Your Ref: OWPC21732
Our Ref: WA/7/19/RES 06-02-2019
Please ask for:
Stuart Corbey

Approval of reserved matters following outline consent WA/26/18/OUT for layout & scale for 6 No. dwellings & 6 No. detached garages.

Lanes End West Walberton Lane Walberton

PJ DEVELOPMENTS LTD 2 Square Chambers 23 High Street Emsworth PO10 7AQ Tel: 0843 289 3430 Email: enquiries@pjdevelopmentsltd.com	
PROJECT: FORMER LANES END	
SITE PLAN OUTLINE PLANNING APPLICATION	
DATE: JANUARY 2019	DWG. NO 19-001 PL02
SCALE @ A1: 1:200	
REV: C

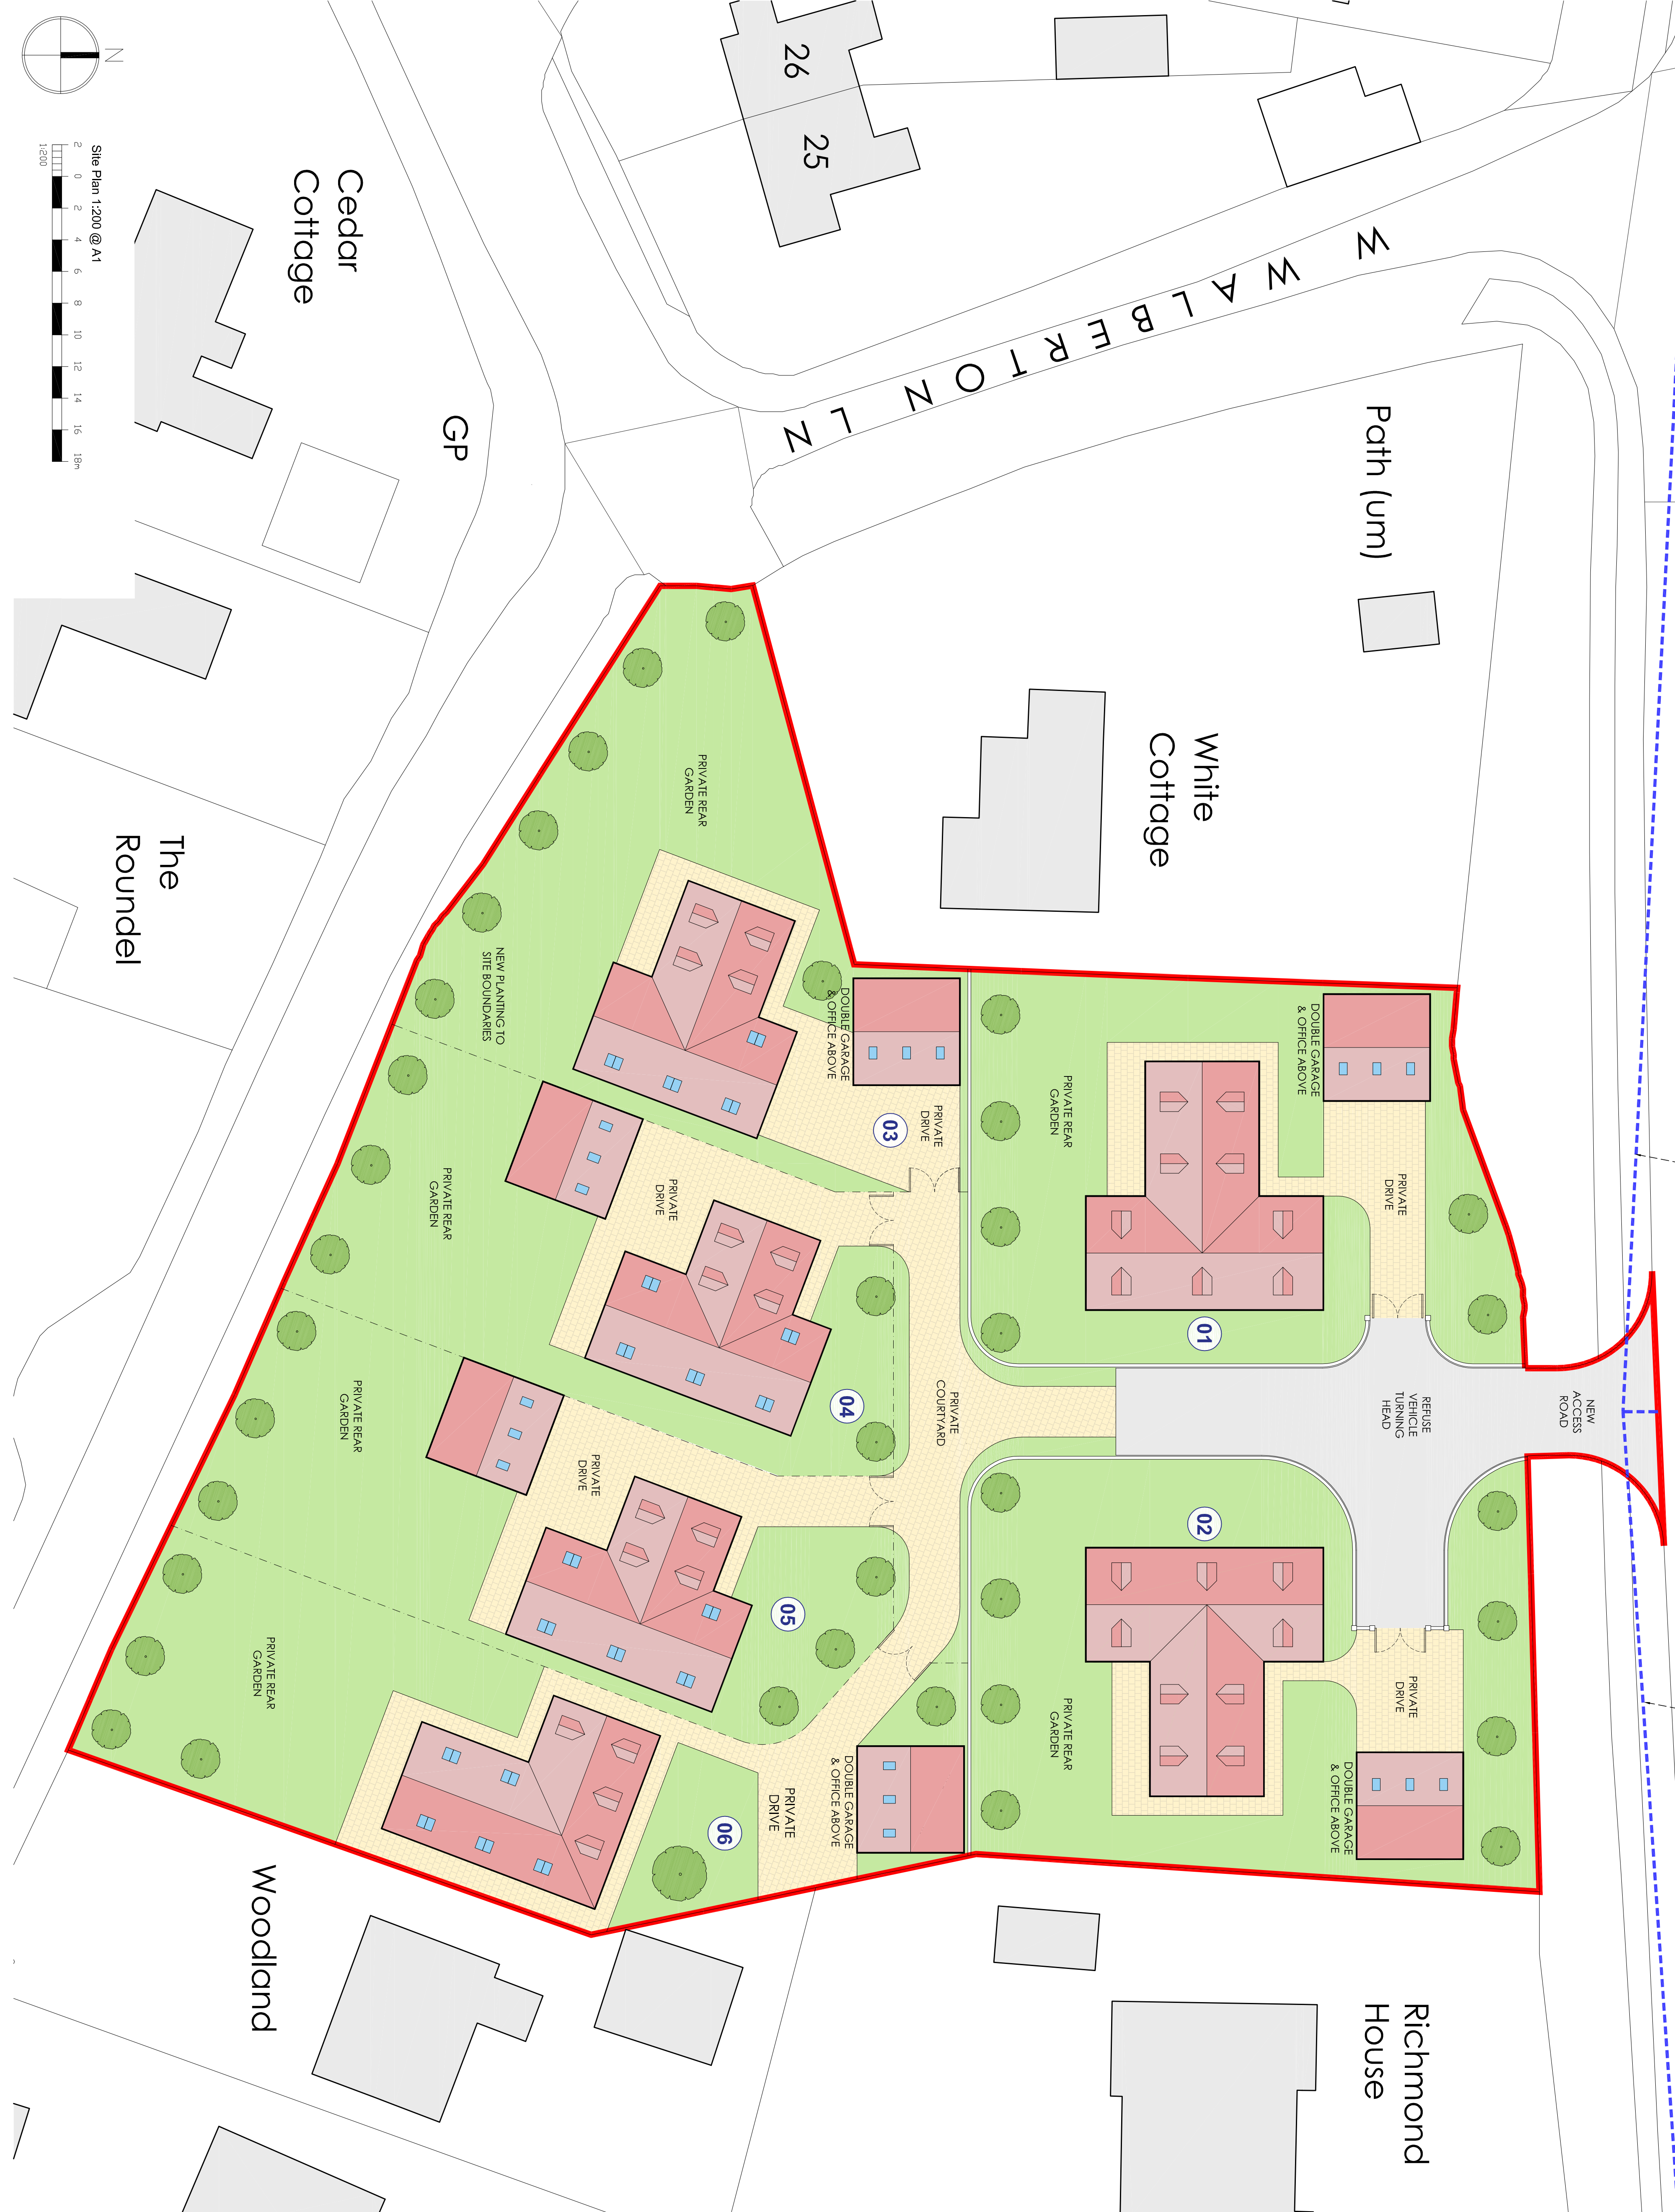
The layout plan stated that all mature trees on the boundary would remain. None of the mature trees on the border in close proximity to the property Woodland, are shown on the drawing accompanying the application. This is very unfair on the residents of Woodland.
